Re: Railway (Metrolink - Estuary to Charlemont via Dublin Airport) Order [2022]
Metrolink. Estuary through Swords, Dublin Airport, Ballymun, Glasnevin and City Centre to Charlemont,
Co. Dublin

Re: Railway (Metro-Link Estuary to Charlmont via Dublin Airport) Order 2022

SUBMISSION

TII METROLINK RAILWAY ORDER APPLICATION

O'CONNELL STREET STATION - LONGITUDINAL SECTION
1 : 200

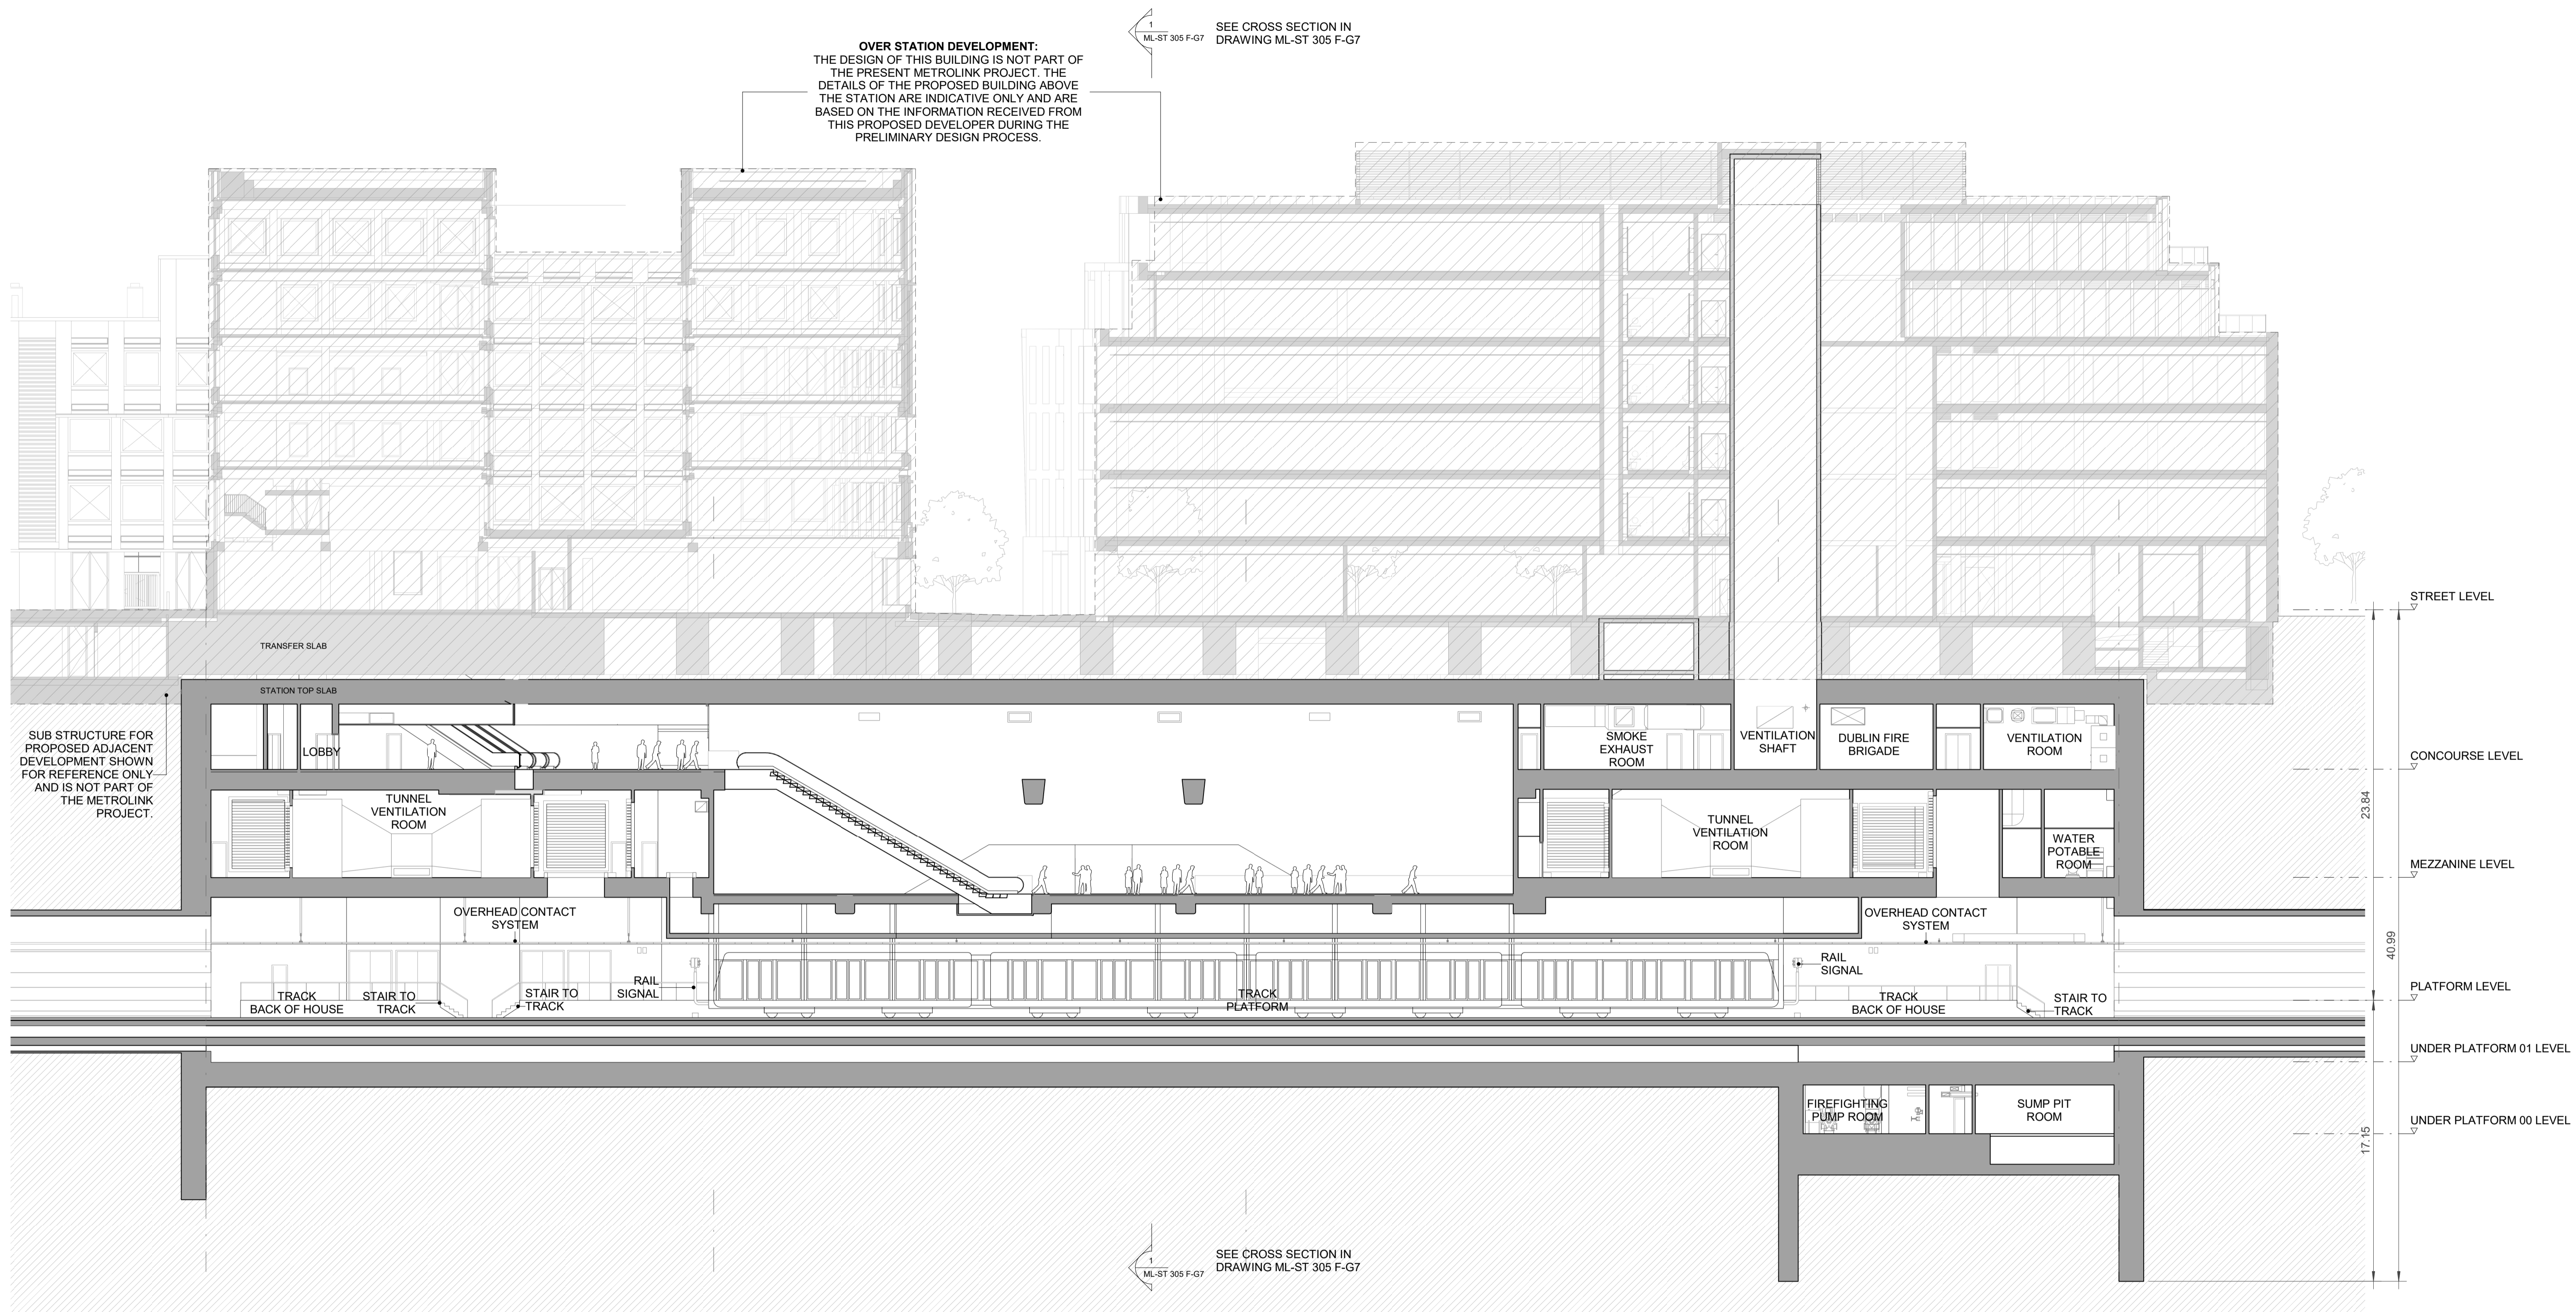
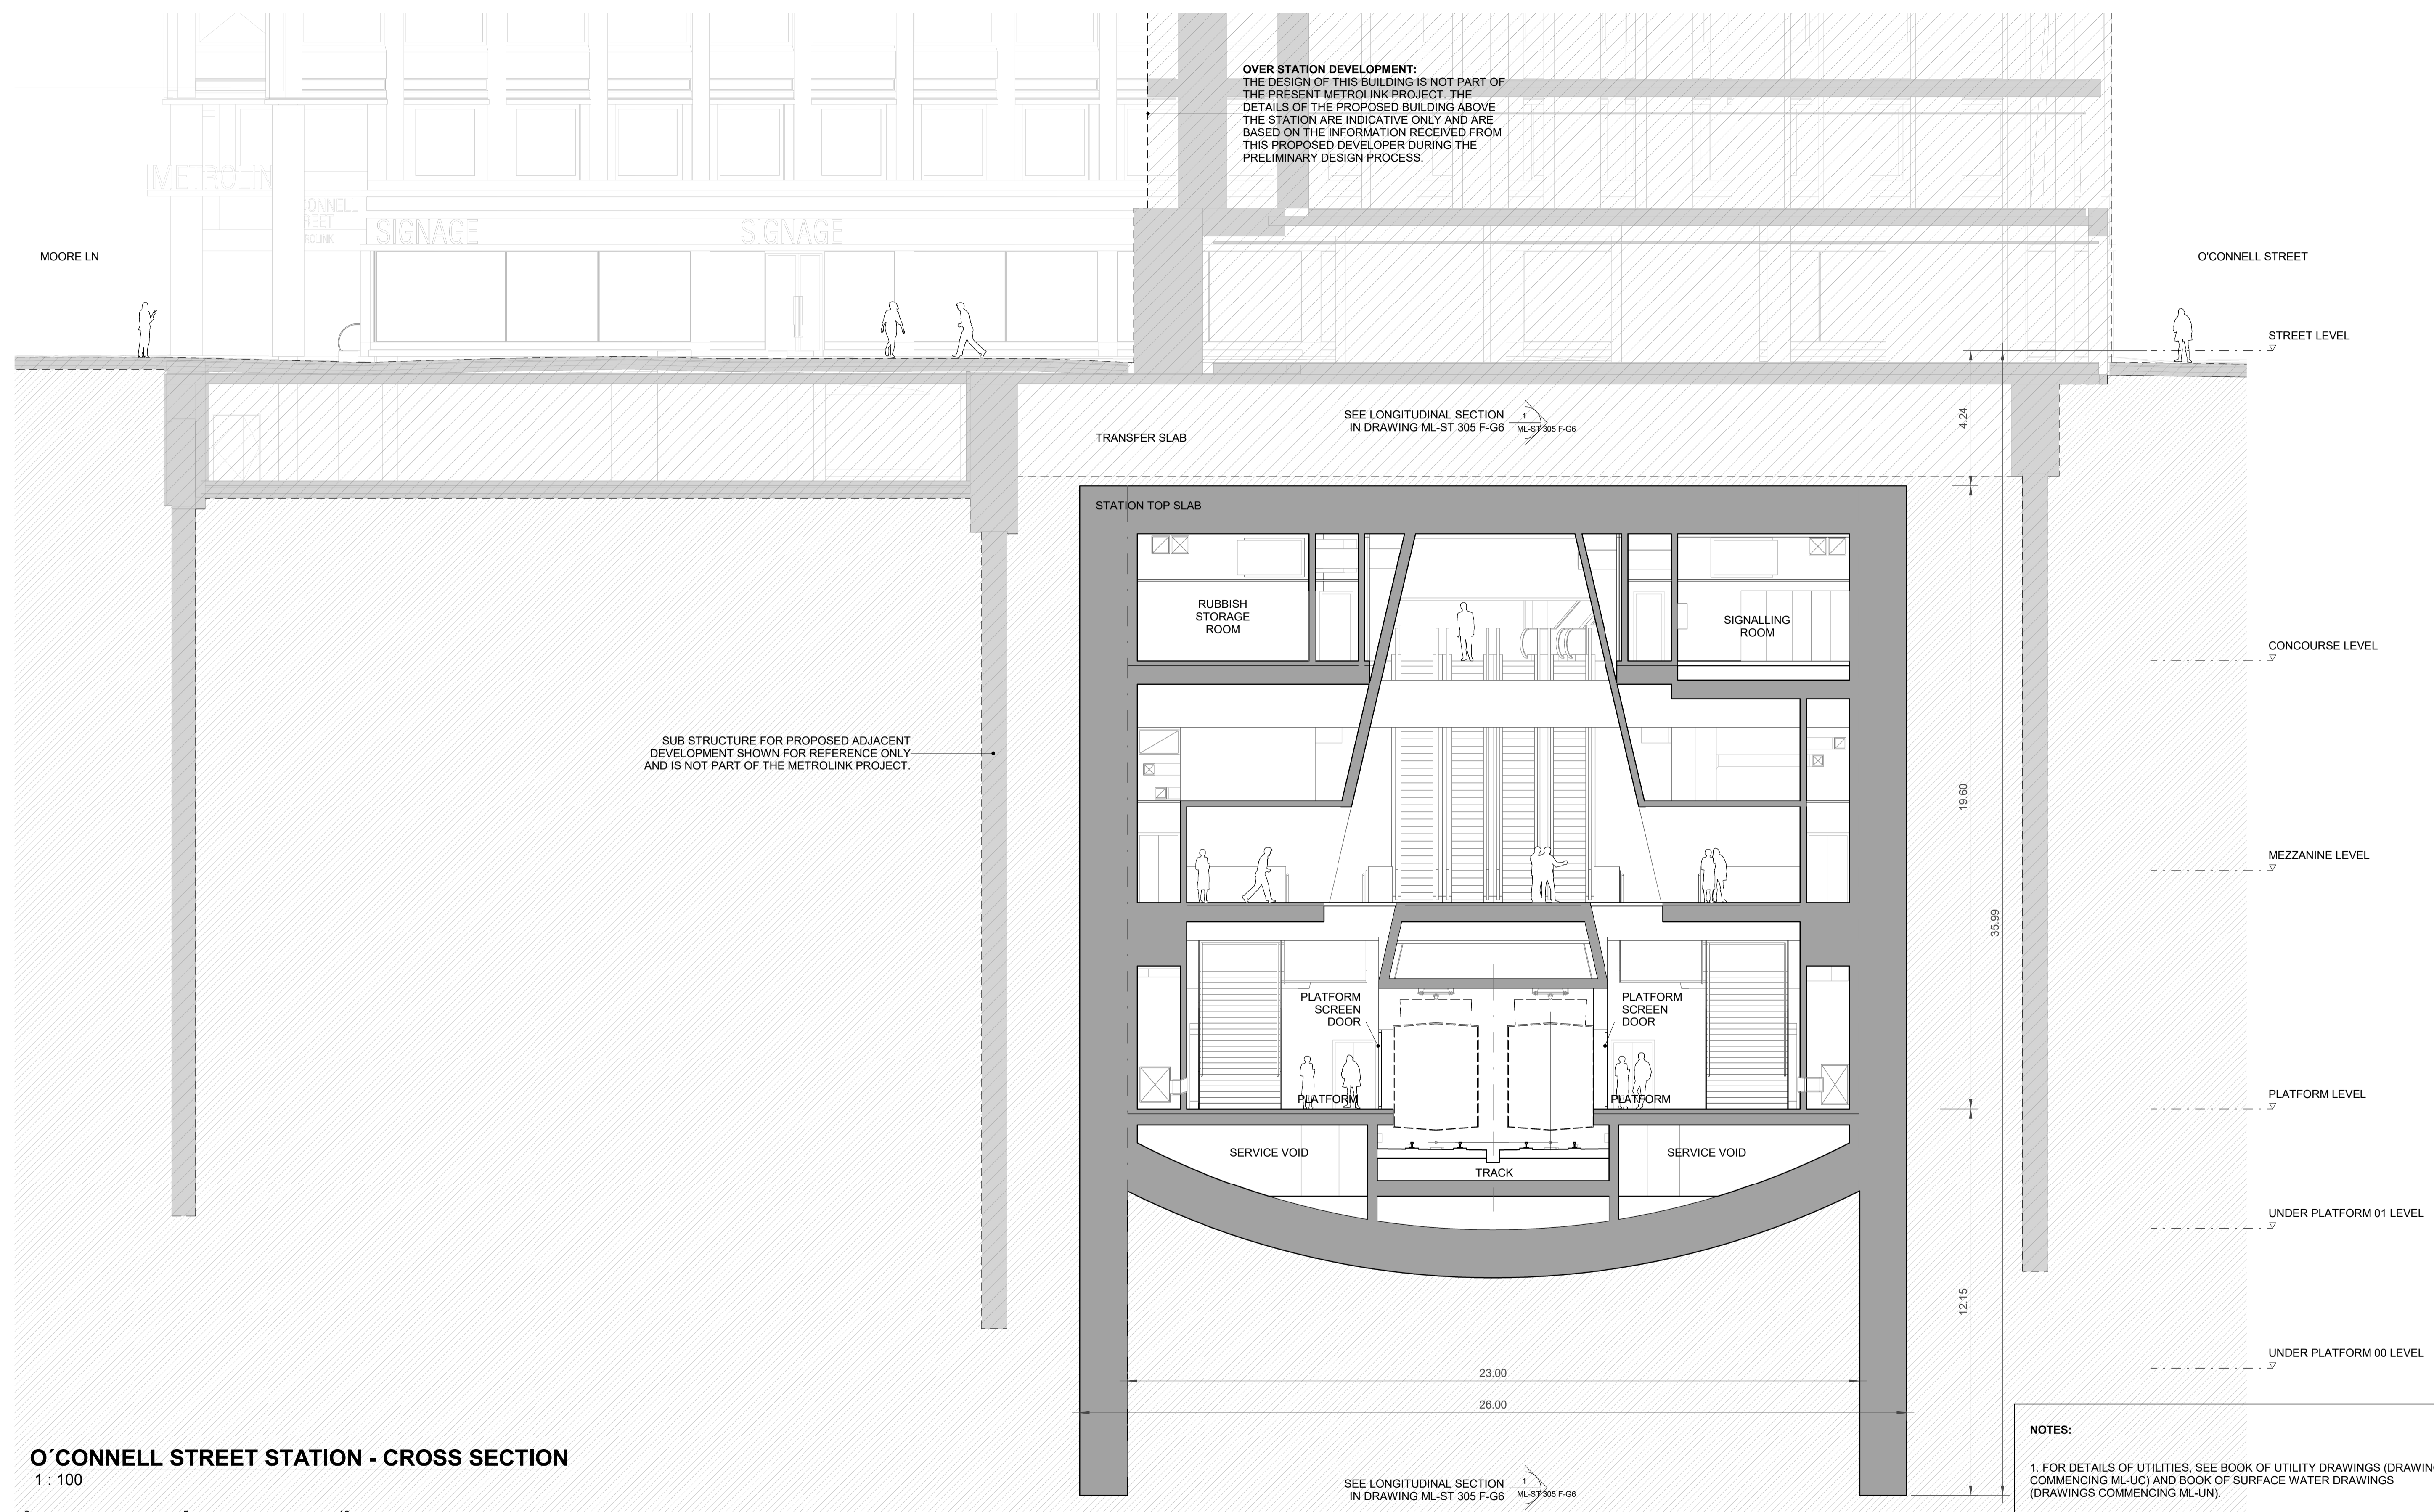
- e. The construction of the deep underground O'Connell St. station is in close proximity to the Rotunda Campus and unclear to what extent assessed for potential impacts on the Rotunda.
